6 March 2013

**Proposed Modification 6 of Development of Thomas Street Carpark – MOD 6  
MP09\_0066 Thomas Street, Chatswood**

1 GROUND FLOOR PLAN  
1:200

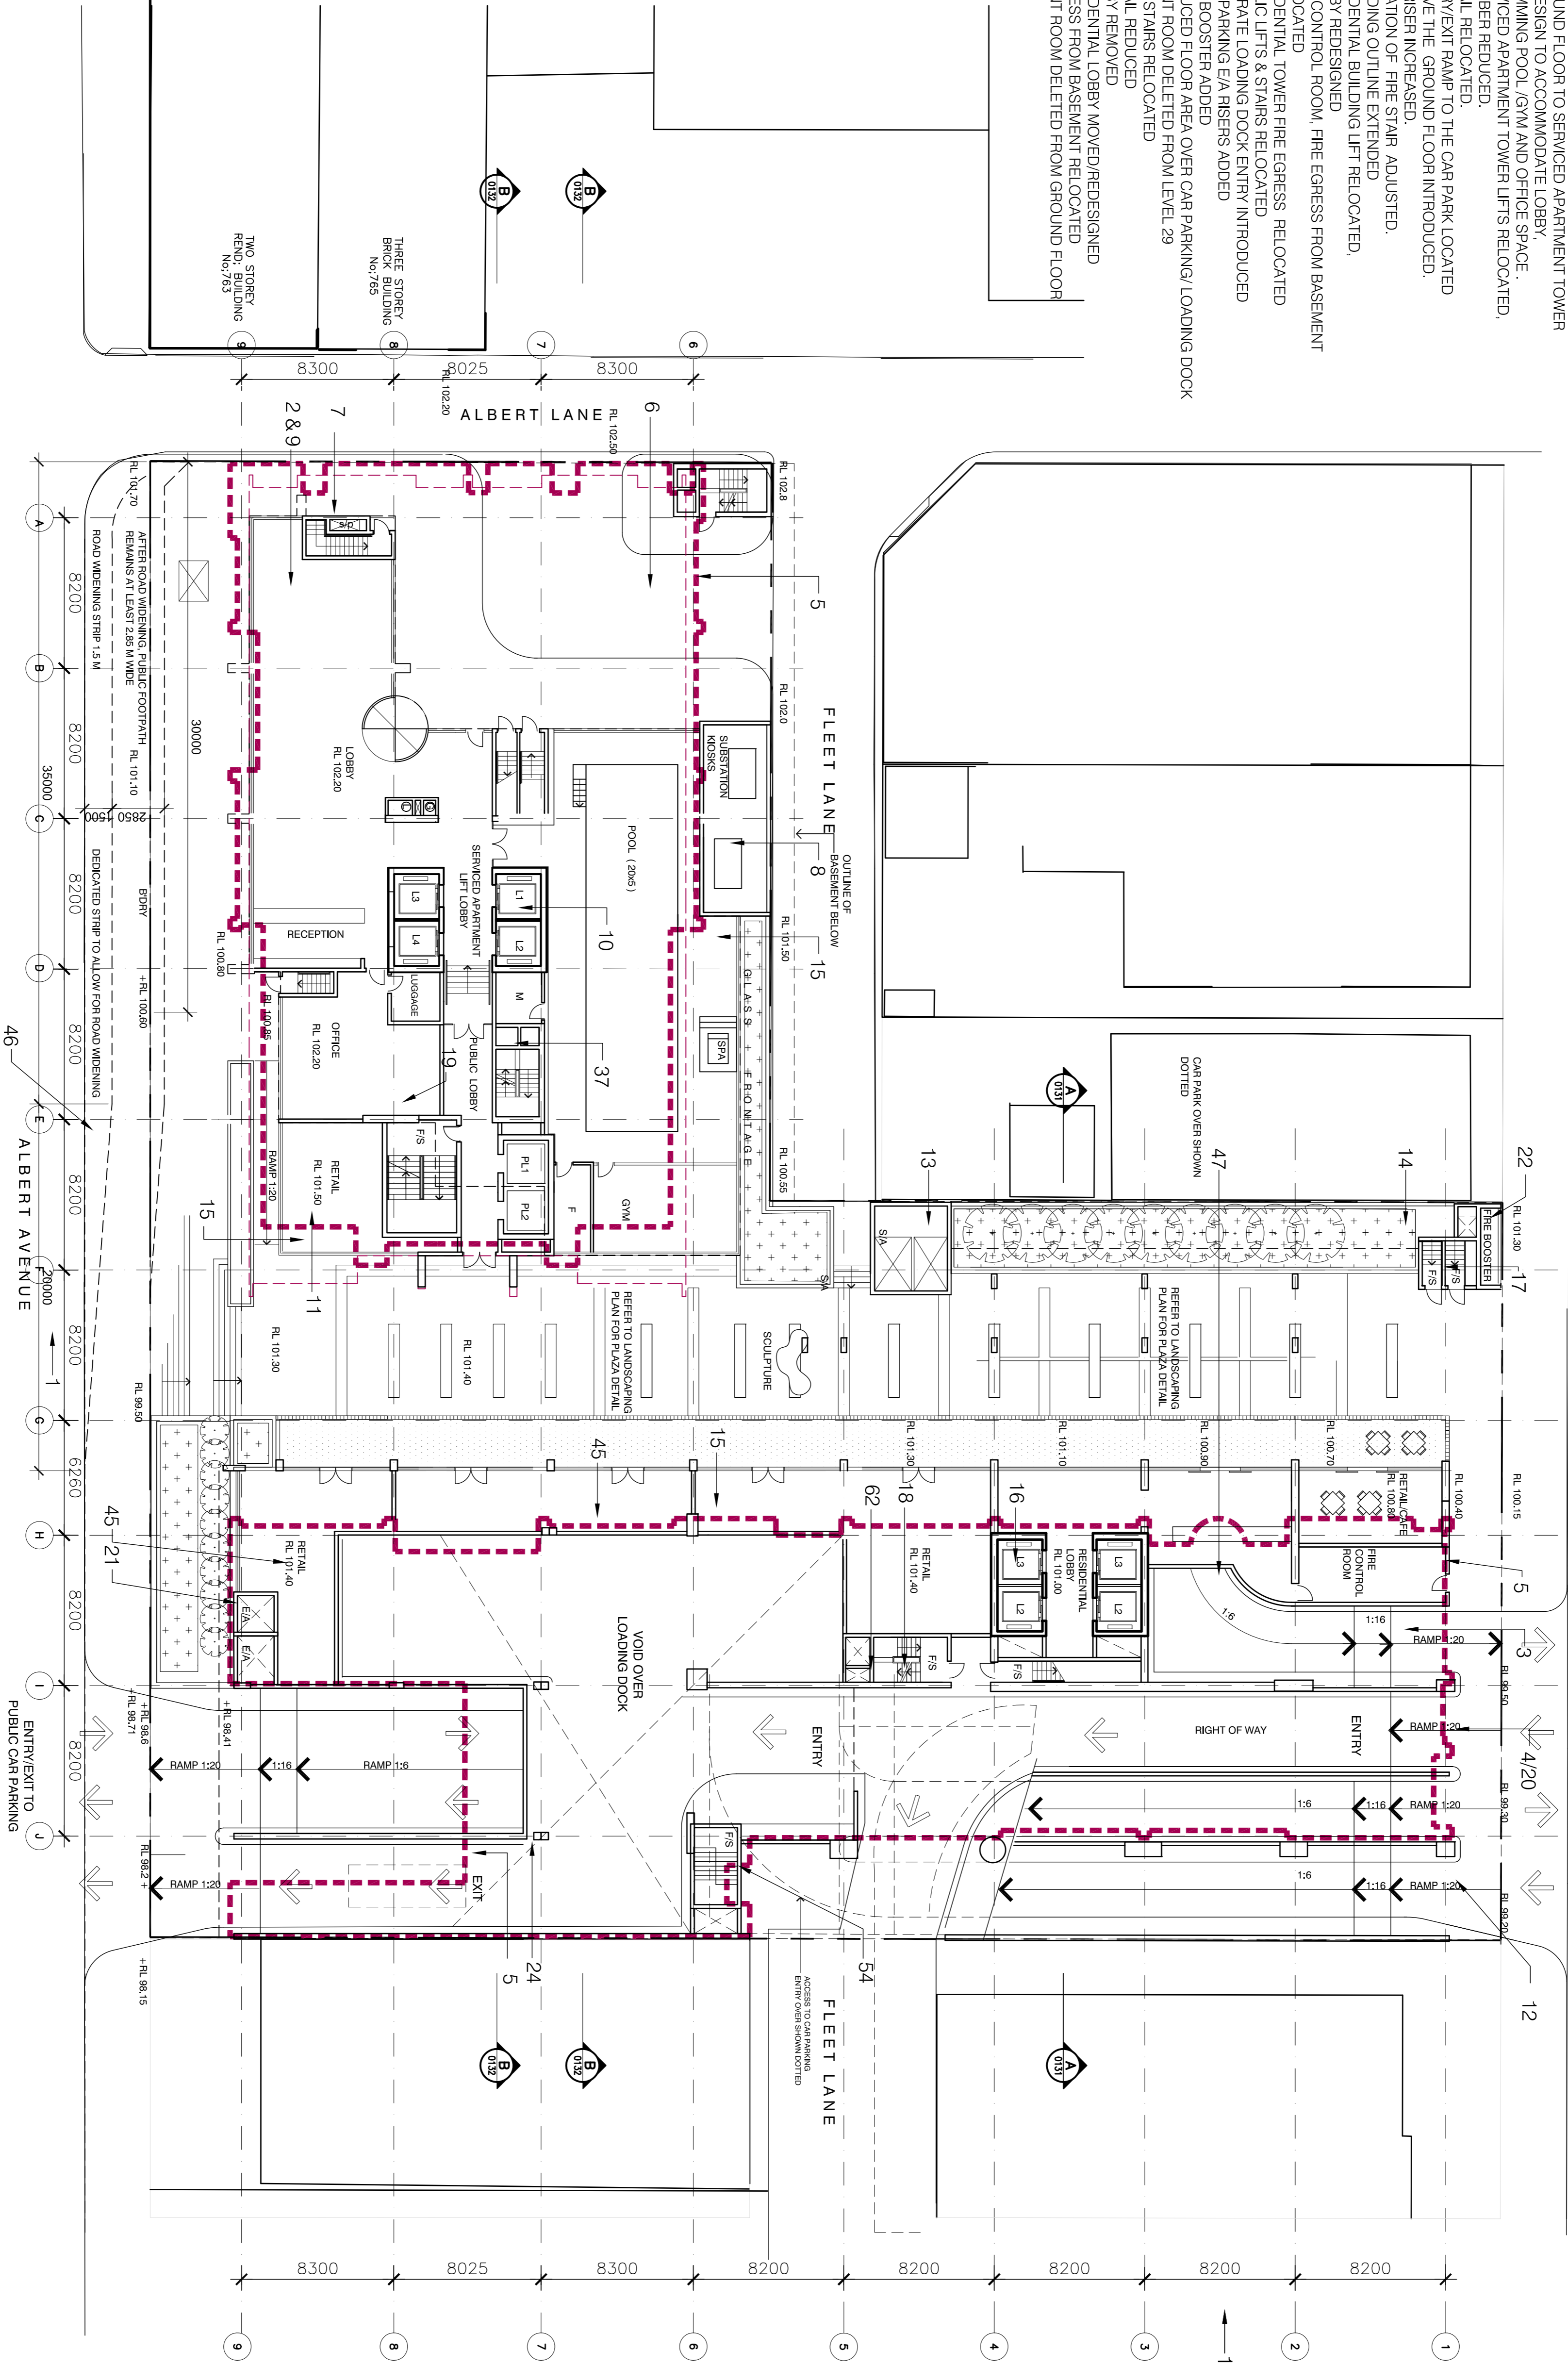
- As a result of the parking there will be an almost blank and ugly facade presenting to Thomas Street with the exception of a cafe that will span just 4 metres compared to 18 metres of driveway. The approved outdoor plaza which would have served as a public domain will be removed.

- Disabled and infirm persons who need to use the access ramp into 12 Thomas Street, which contains medical practices, will have a circuitous access to that address. They will have to travel around the backs of the proposed high-rise buildings compared with the previous direct access.

- Access ways that were formerly used for pedestrians to travel between Albert Avenue and Thomas Street will not be available.
- Fleet Lane which used to be a public street available for motorists and pedestrians accessible to Albert Lane has been partially removed, and no replacement pedestrian access way is provided.

1 ELEVATION – SOUTH
1:250

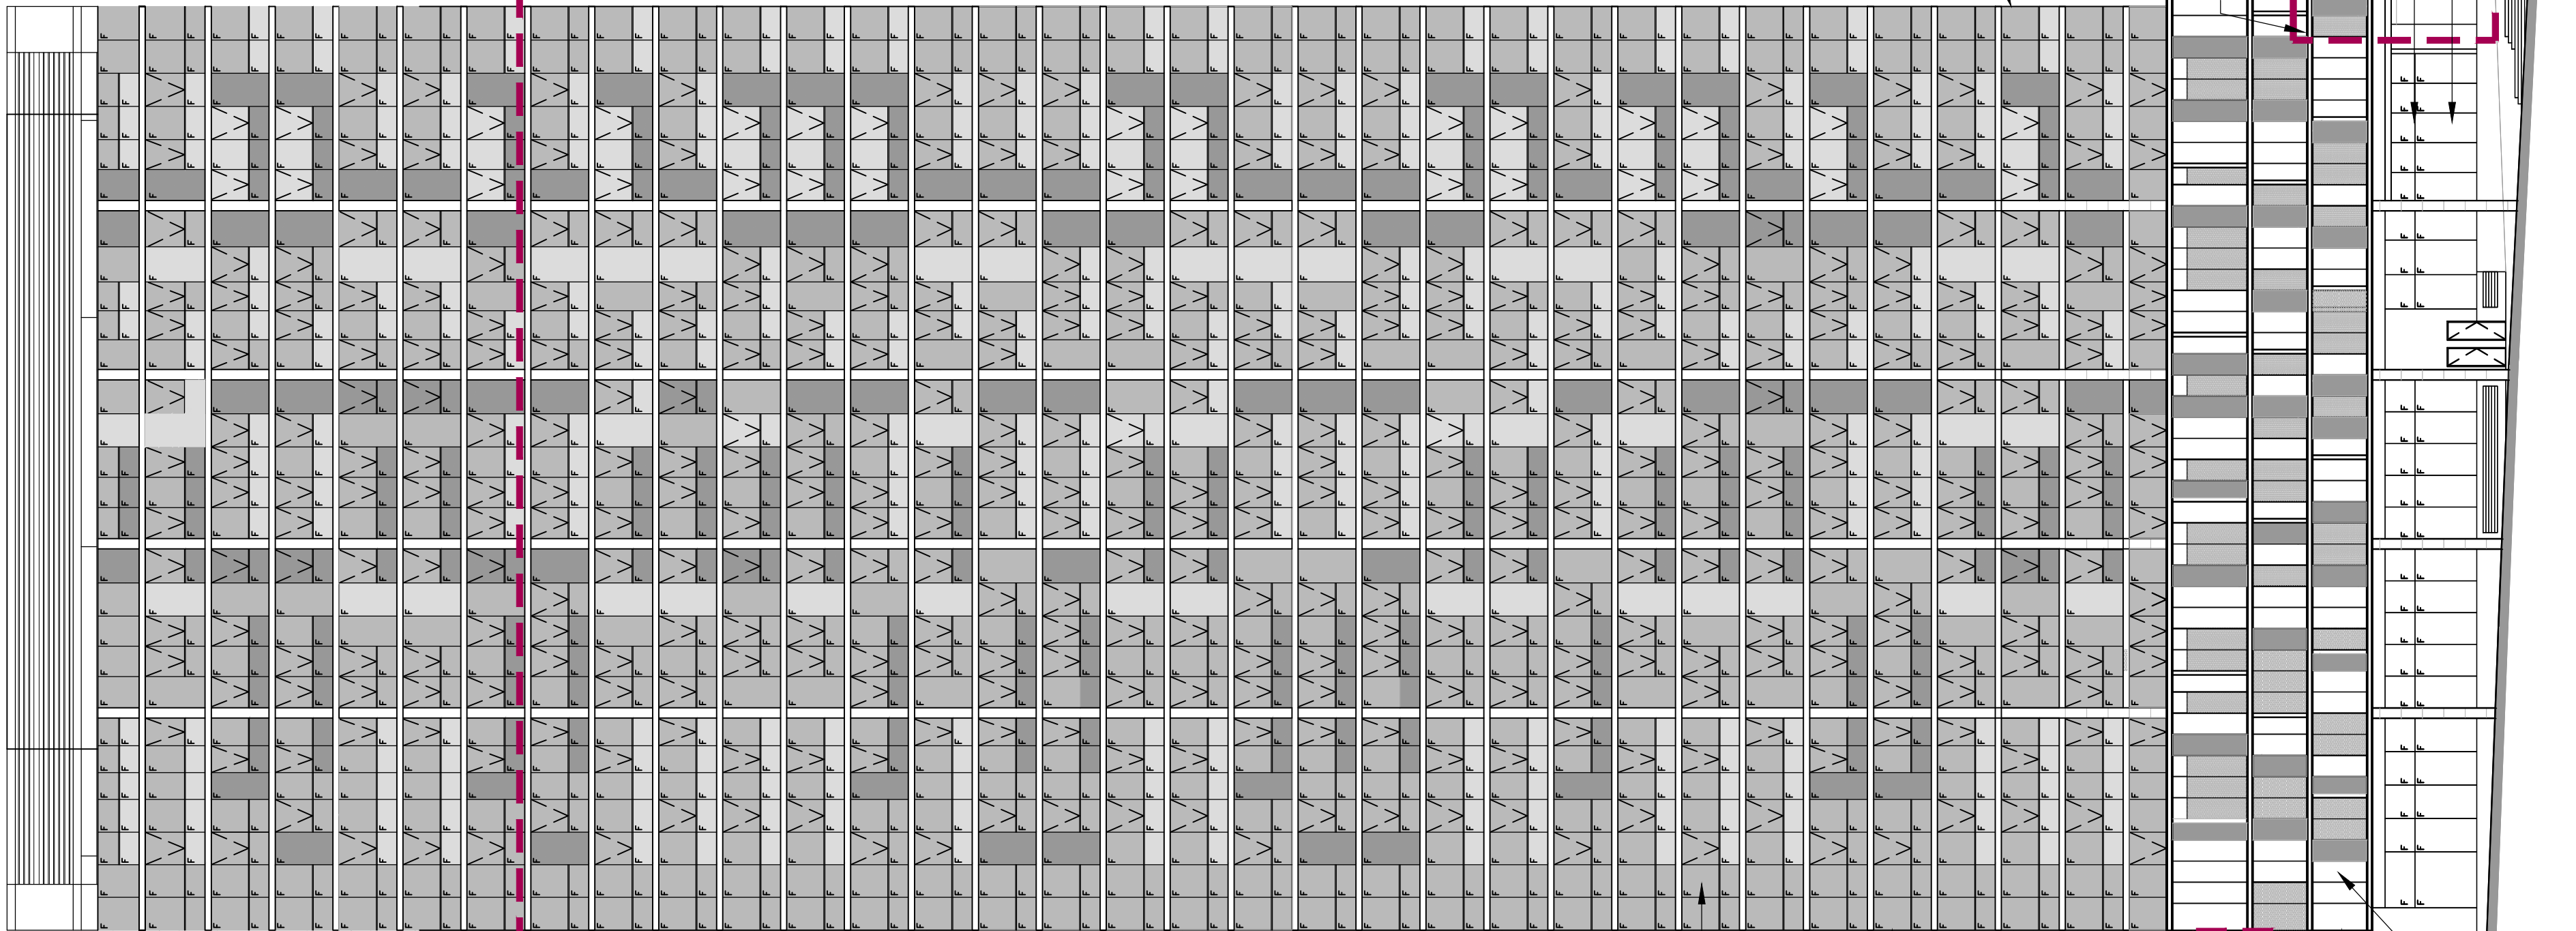
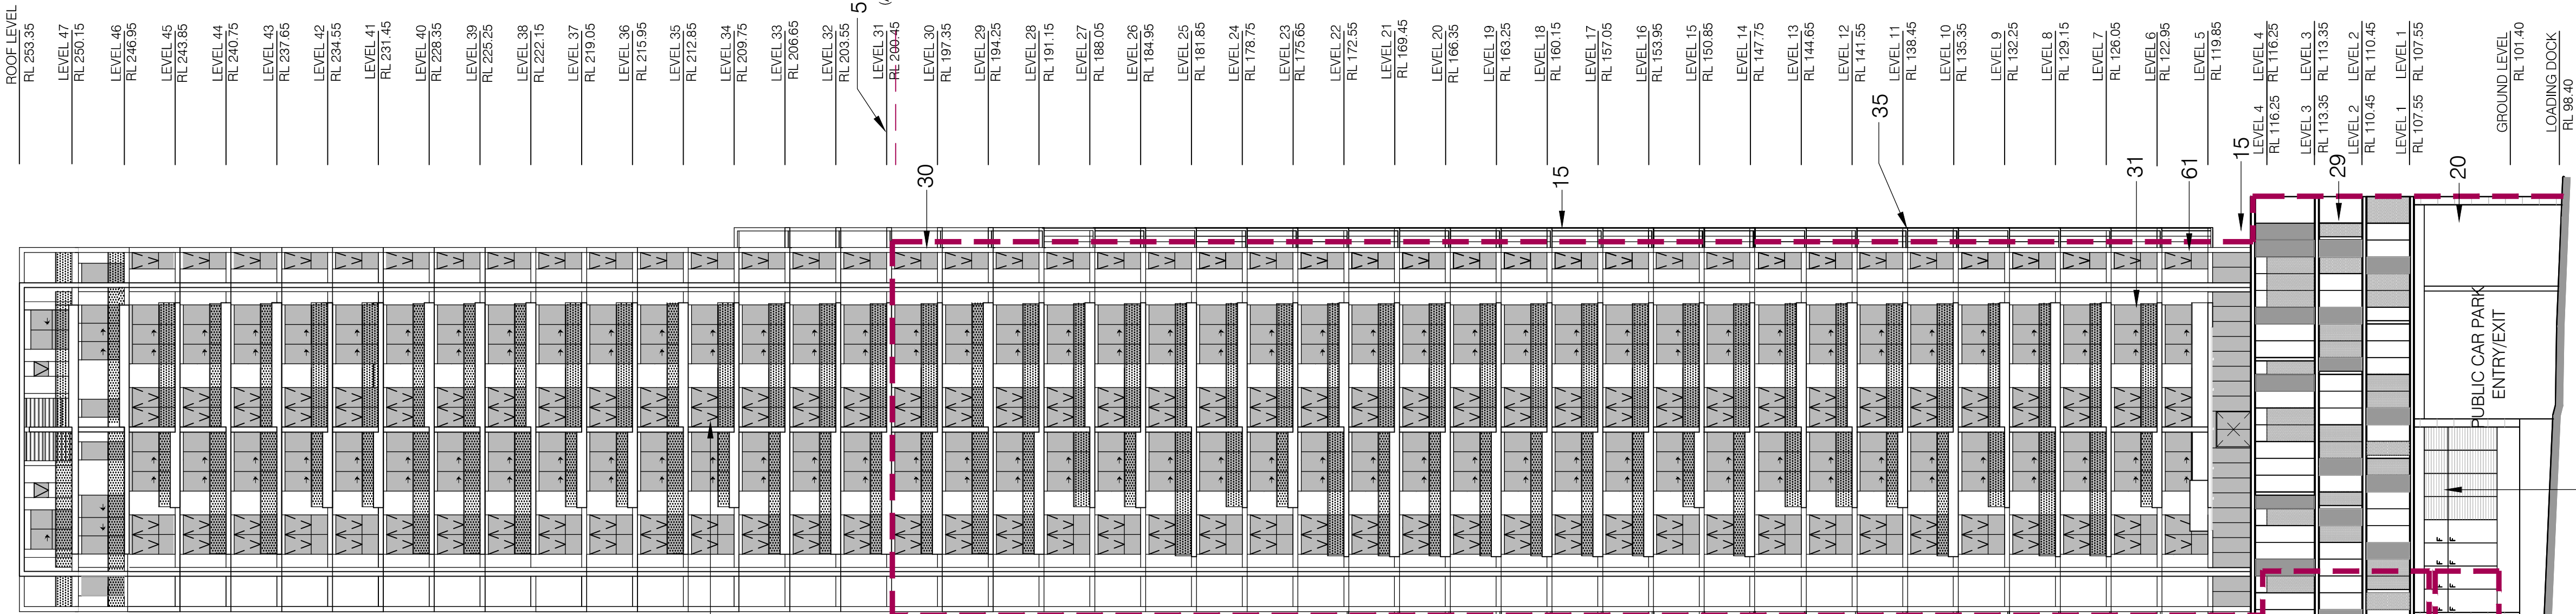
- Use – from a mixed use development to serviced apartments and residential flats
- Tower A (being the one closer to Thomas Street) – from 29 storeys to 37 storeys

- Tower B (being the one closer to Albert Avenue) – from 29 storeys to 47 storeys
- Removing the proposed and approved child care and adding 3 floors of above ground level parking.

- A loss of visual amenity. The proposed towers will have a high visual impact, dominating the skyline, and will be out of character with the surrounding buildings and in that way obtrusive.
- An increase in noise.
- Overshadowing – to put the height of the buildings in perspective, the buildings at 473 - 501 Victoria Ave are 13 storeys high while the proposed towers are 47 storeys.
